From: Simon Davis
Sent: 17 June 2021 10:28
To: MarkRobinson [REDACTED]
Cc: Tim Willment [REDACTED]
Subject: RE: The Croft Surgery, Eastergate BN/62/21/PL

I note that when we assessed the RSA for the previous application for The Croft, we advised that the neighbouring site, Eastergate Fruit Farm was required (by way of S106 agt) to provide a pedestrian crossing which would overcome the problem raised within The Croft's RSA. I note that the permission for Eastergate Fruit Farm lapsed in May this year.

Project: The Croft Medical Centre		
Title: Proposed Access Arrangement and Visibility Splays		
Scale: 1:250 (@ A3)		
Notes:		Revision: A
Drawing: 2011094-01

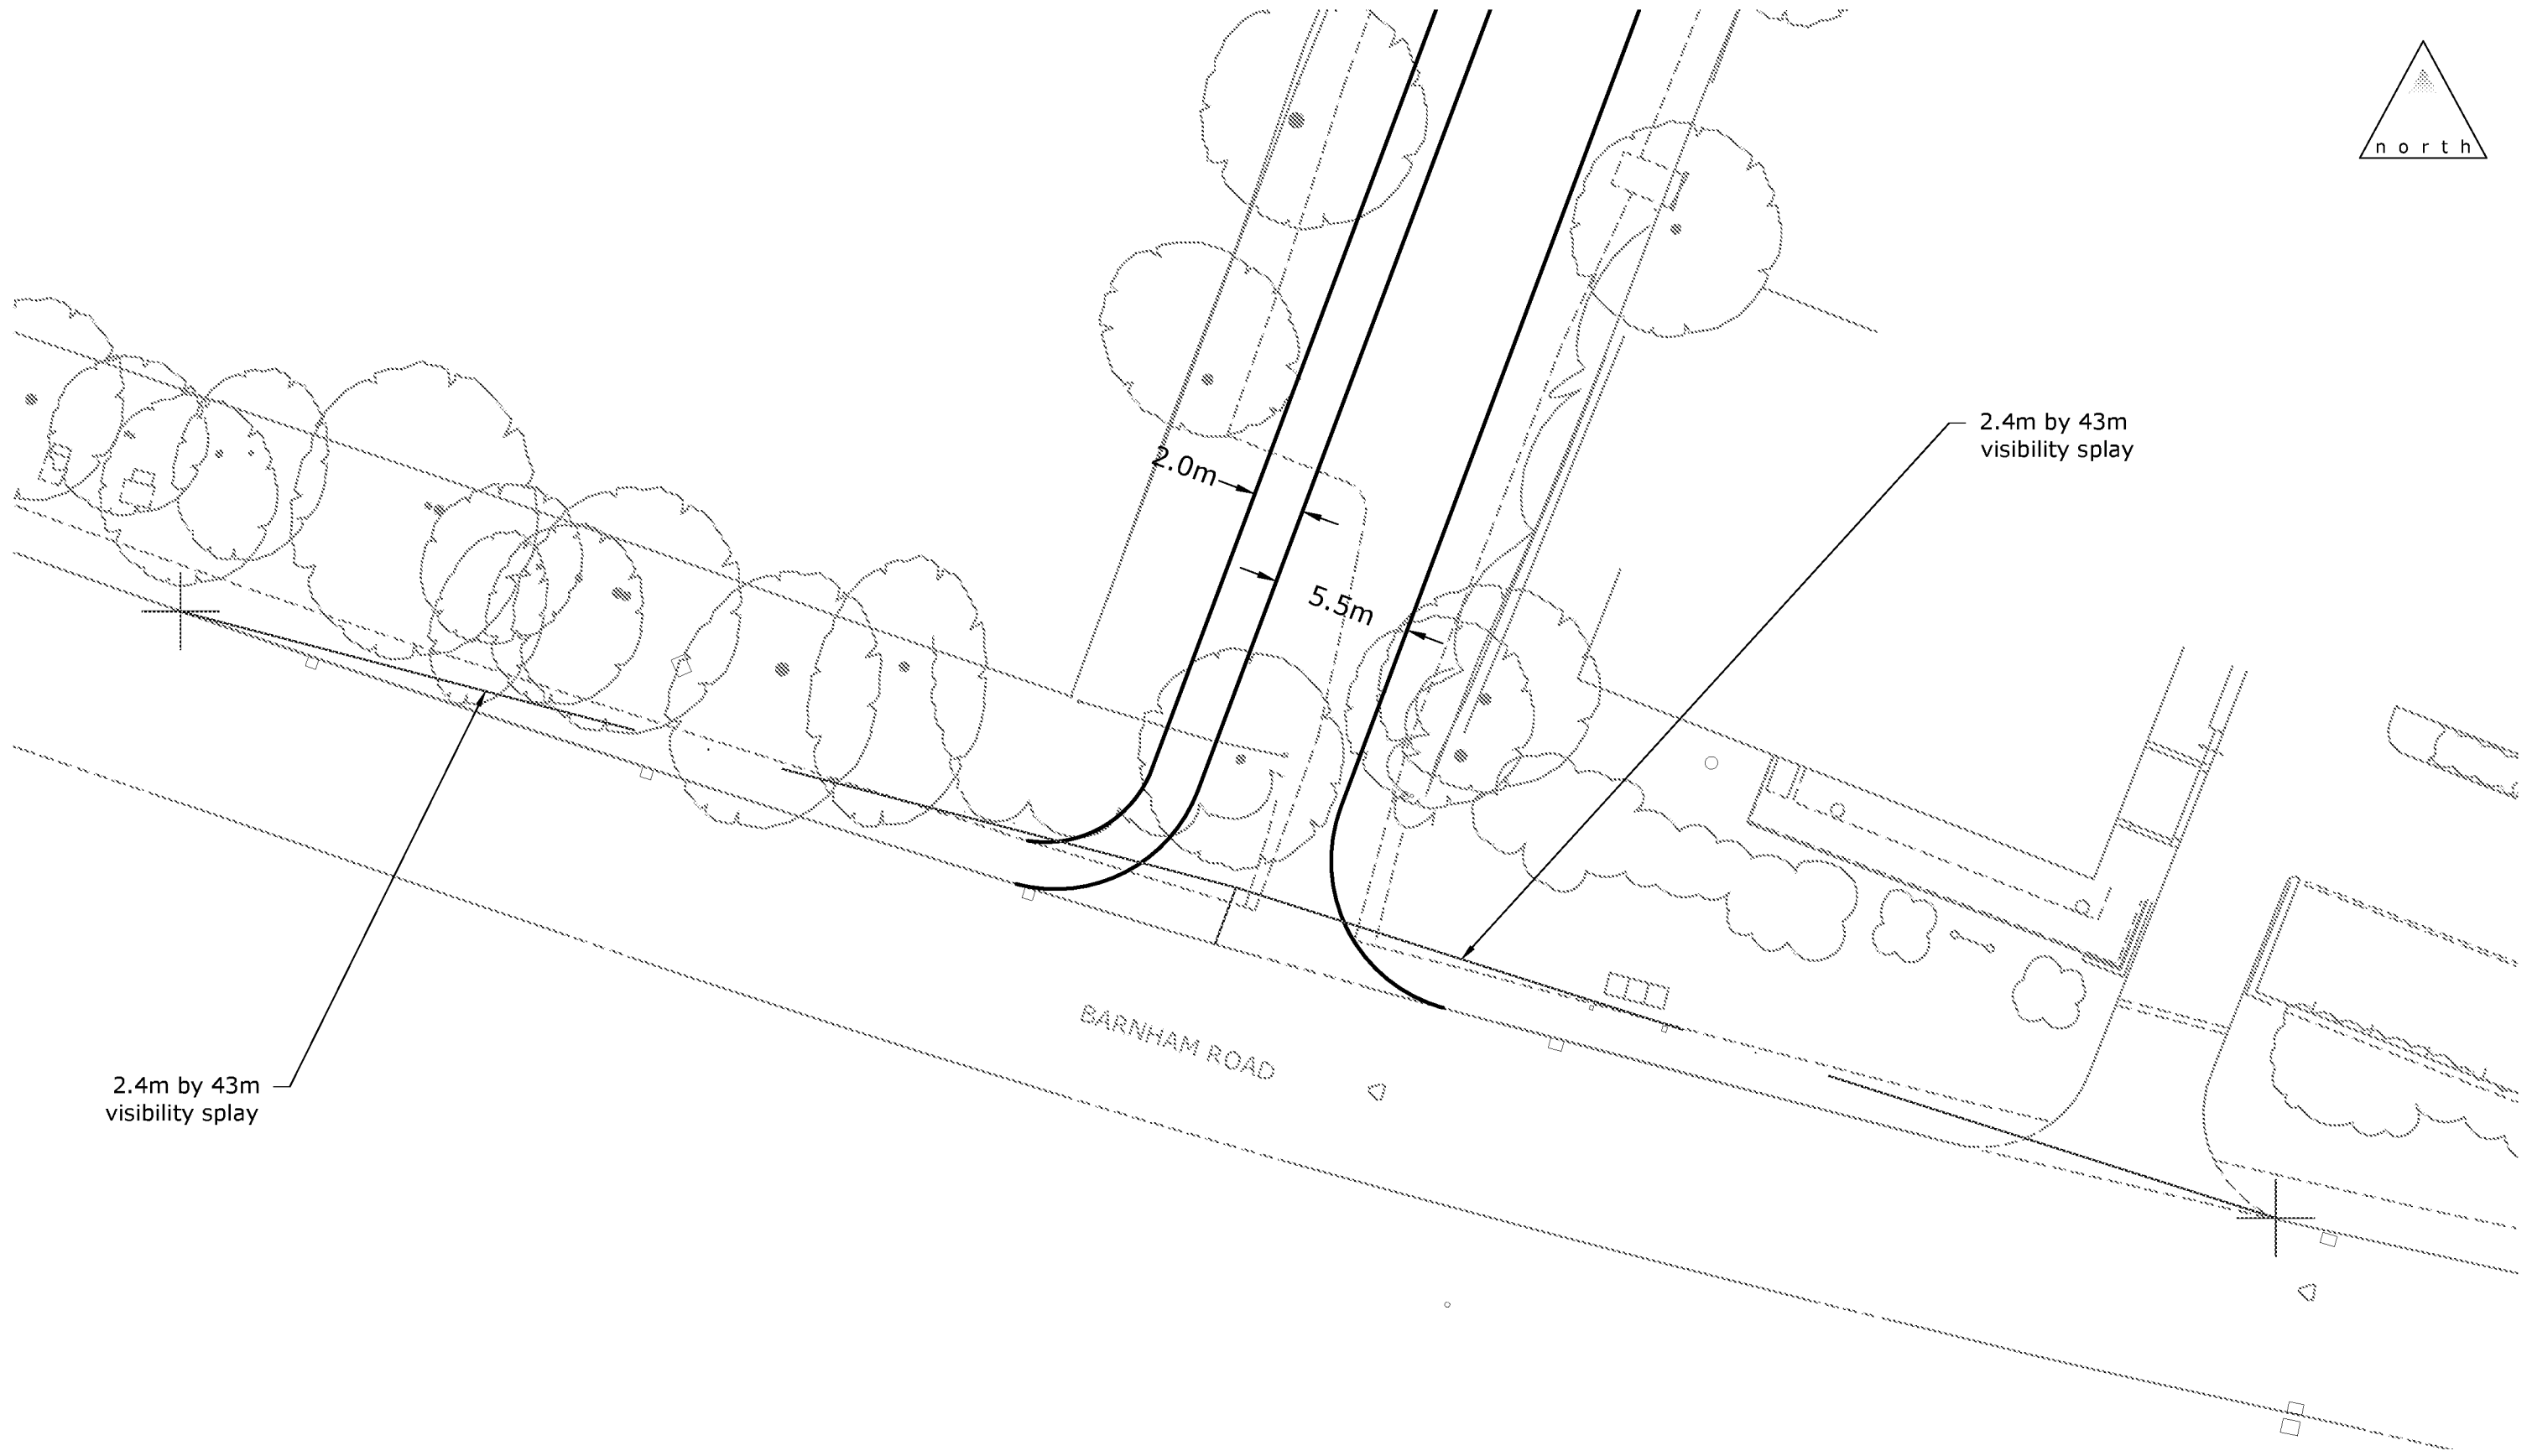
I am thinking that (subject to the original Croft RSA being signed off as compliant with the new GG119 standard) we should be looking to secure the pedestrian crossing works as part of this application. If in the meantime, another application for Eastergate Fruit Farm comes forward, we would again secure the pedestrian crossing under the S106 agreement and essentially whichever development is implemented first would then be required to carry out the works. Does this seem like a reasonable way forward to you?

We are not aware of any proposed resubmission on the Fruit Farm and so I have agreed with Highways that it is reasonable to request a pedestrian crossing. This would necessitate you entering into a s106 agreement with us and the County. Is this something your client could agree to?
